Rezoning Transportation Analysis

Petition Number: #2022-157

General Location Identifier: 02912112

Date	Description
02-22-23	First Review (TM)
04-20-23	Second Review (ME)

REZONING SITE PLAN

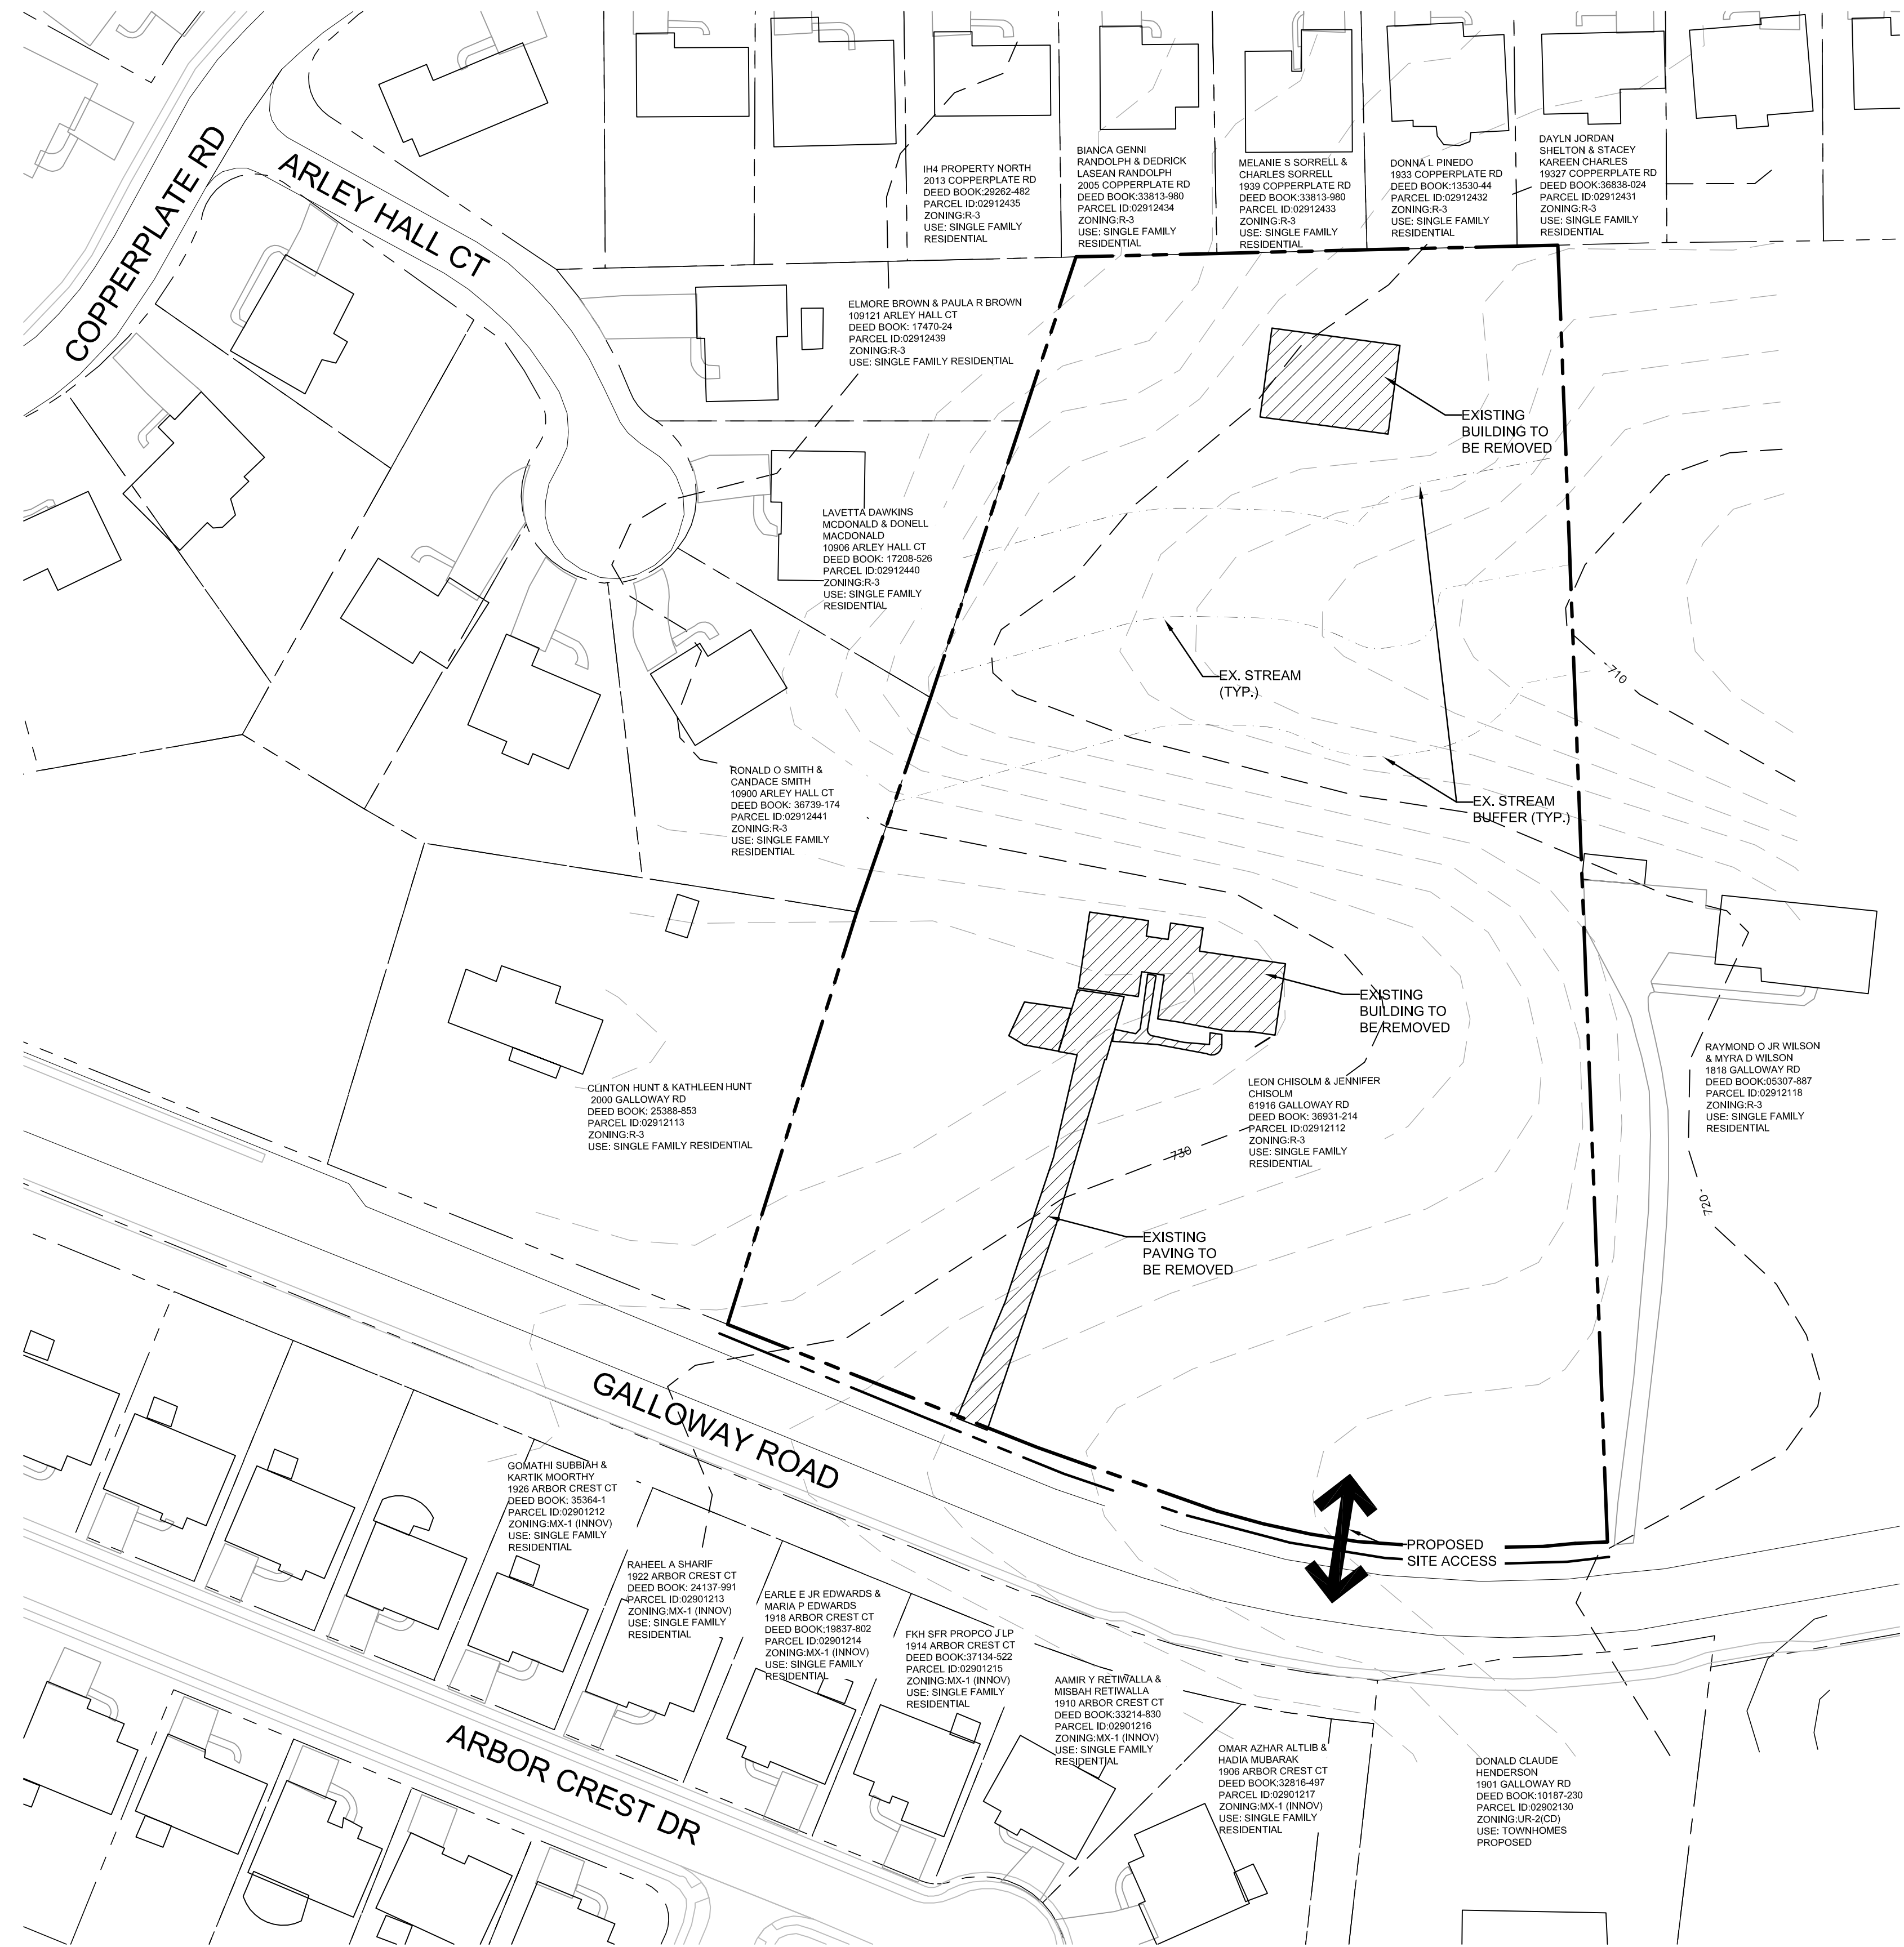
4. **Outstanding Comment From 02-22-23:** Revise site plan and conditional note(s) to commit to providing 75-feet of internal protected stem. Dimensioned from curb return to curb return.

Clarifying Comment 04-20-23: Revise site plan by dimensioned from curb return to curb return.
